Engineers Comments Regarding Surface Water Drainage

Application Reference:	BE/132/25/DOC	Reviewer Reference:	ADC/EXT5/AF
Planning Officer:	Daniel Vick	Date of Review:	18/02/2026
Site Name:	Former Bartons County Infants School Romney Broadwalk Bersted PO22 9BH		
Application Description:	Approval of details reserved by condition imposed under BE/40/22/PL relating to conditions 23-maintenance and management of SuDS drainage and 24-construction of surface water drainage system (see BE/133/25/DOC for discharge of condition 18-lighting design for biodiversity).		
Assessment Number:	2

Application Reference: BE/132/25/DOC Site Name: Former Bartons County Infants School Romney Broadwalk Bersted PO22 9BH	Initial Issue Date: 10/12/2026 Issue Date: 18/02/2026 Reviewer Reference: ADC/EXT5/AF
---	--

ATTENUATION TANK DETAIL SDS

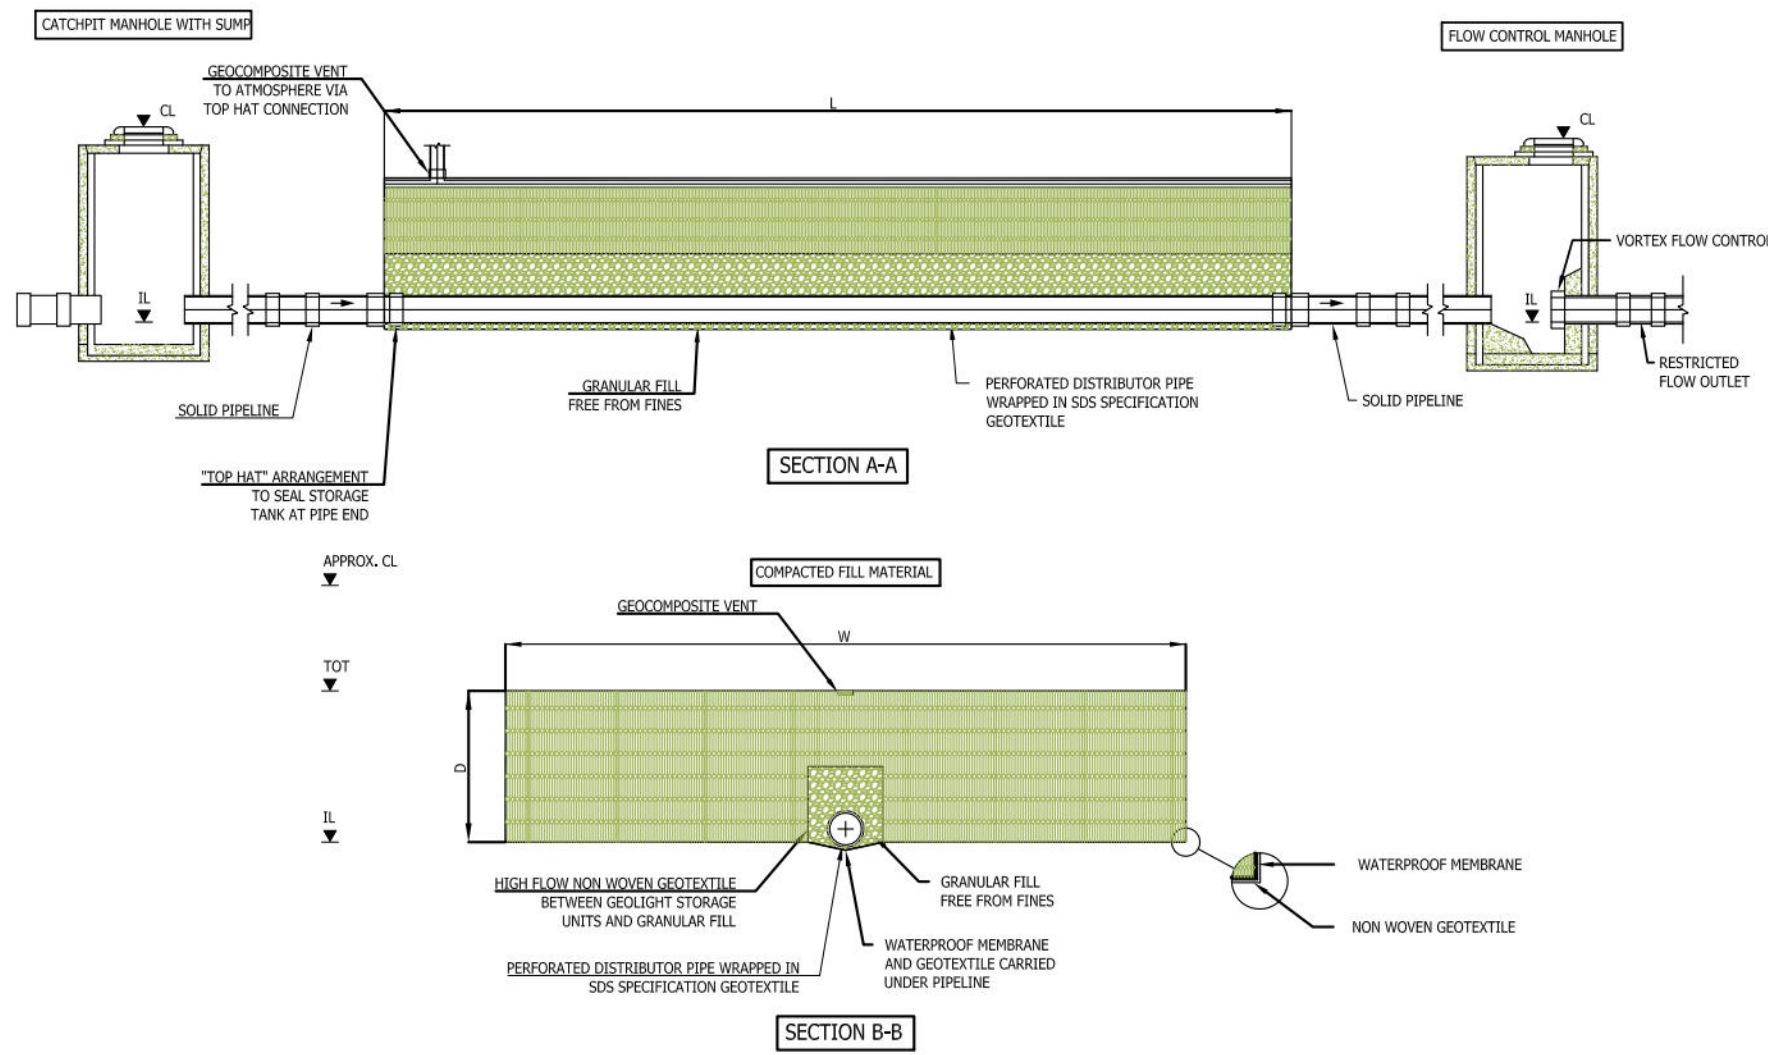
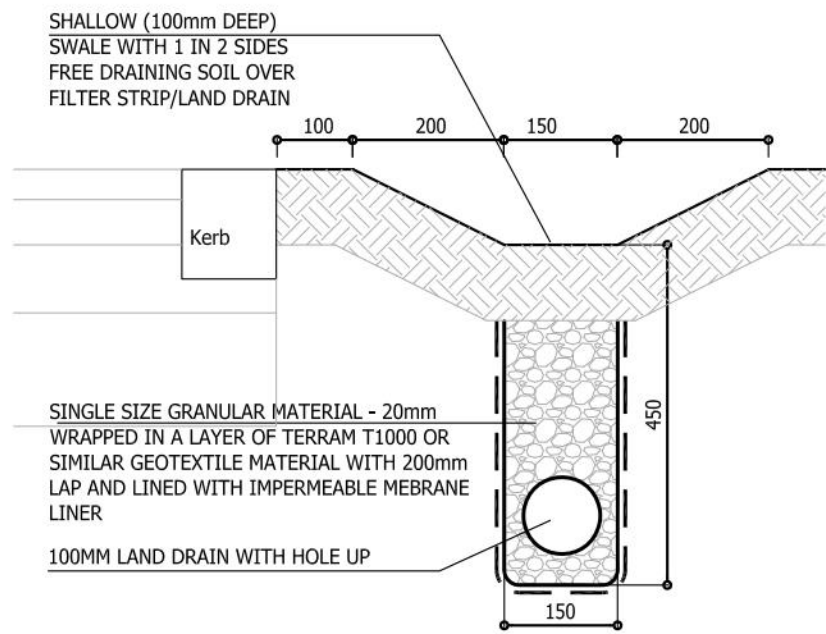
2.	The size/volume of modular storage installation and associated stone attenuation should be evidenced by survey / photograph and the impermeable liner should be evidenced.	An as-built survey of the attenuation tank and enlarged installation photos are provided in Appendix A.	Comment Closed.

Appendix C – Flow Control

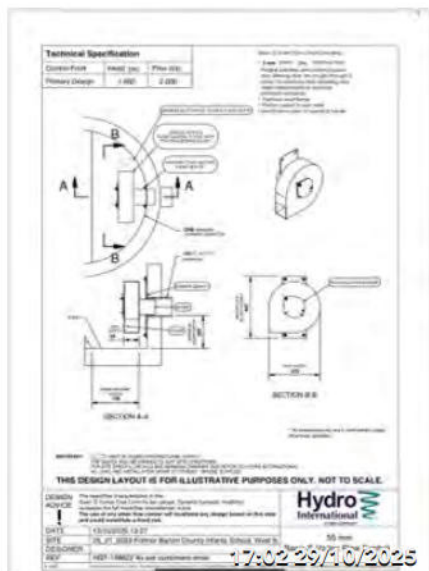
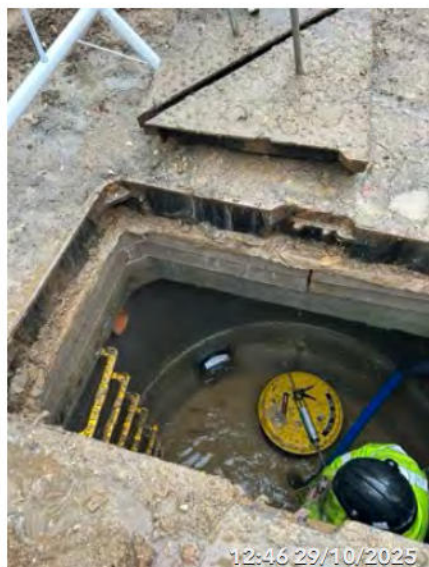
4.	The hydrobrake flow control device product cannot be confirmed from the photos provided.	A higher definition photo of the installed product label and a technical specification are now provided in Appendix C of the revised report	Comment Closed.

Appendix E – Swale

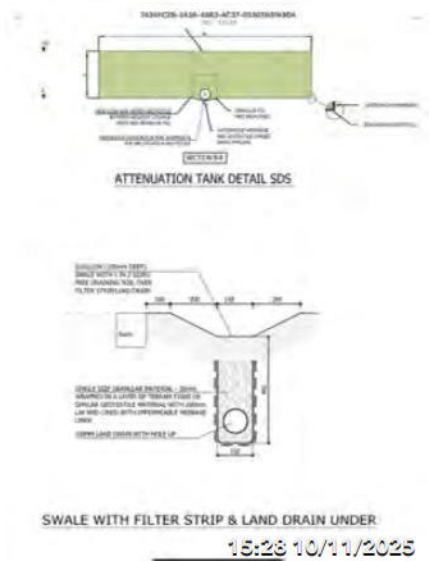
3.	The completed roadside swales should be evidenced.	Photos of the completed roadside swale are now provided in Appendix E of the revised report.	Comment Closed.
